From: Martyn White
Sent: 07 December 2018 15:15
To: Planning.Responses
Cc: Zac Denton
Subject: AB/121/18/HH

AB/121/18/HH

The application relates to the insertion of a second roof light on the rear elevation of the property.

PROPOSED REAR SOUTH EAST ELEVATION
SCALE 1:100

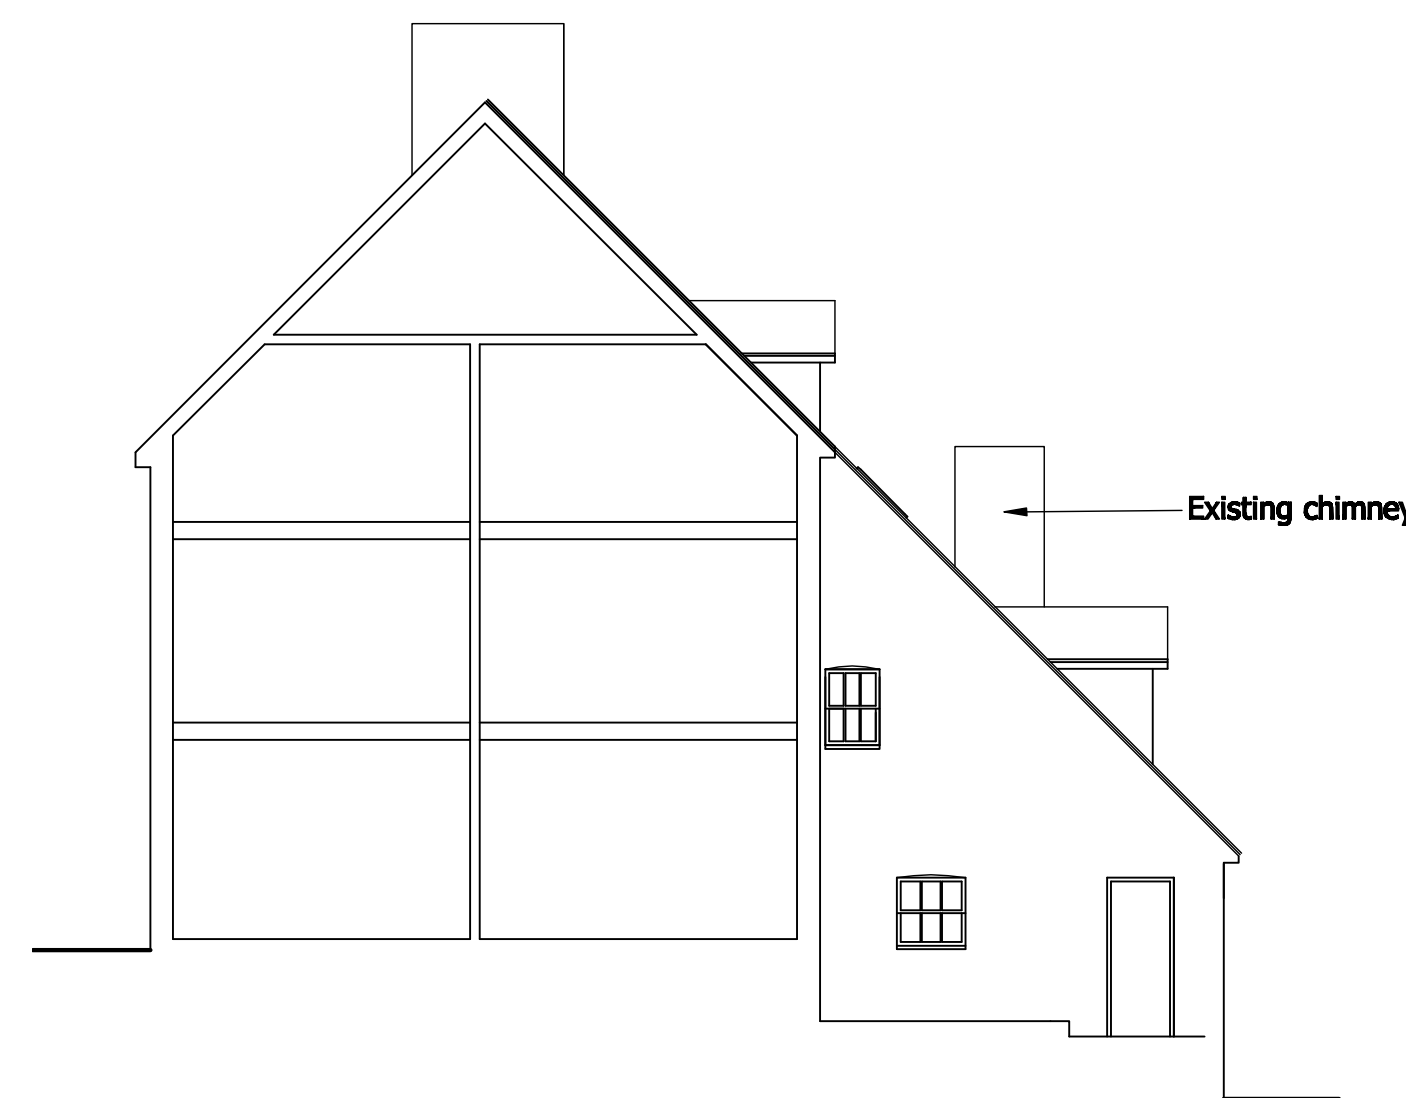
Whilst the proposal would result in a clustering of openings on the rear elevation, its size will mean that it will have a neutral impact on the building. As a consequence, the proposal is capable of support.

It is recommended that the roof light is of conservation design so as to further minimise its impact.
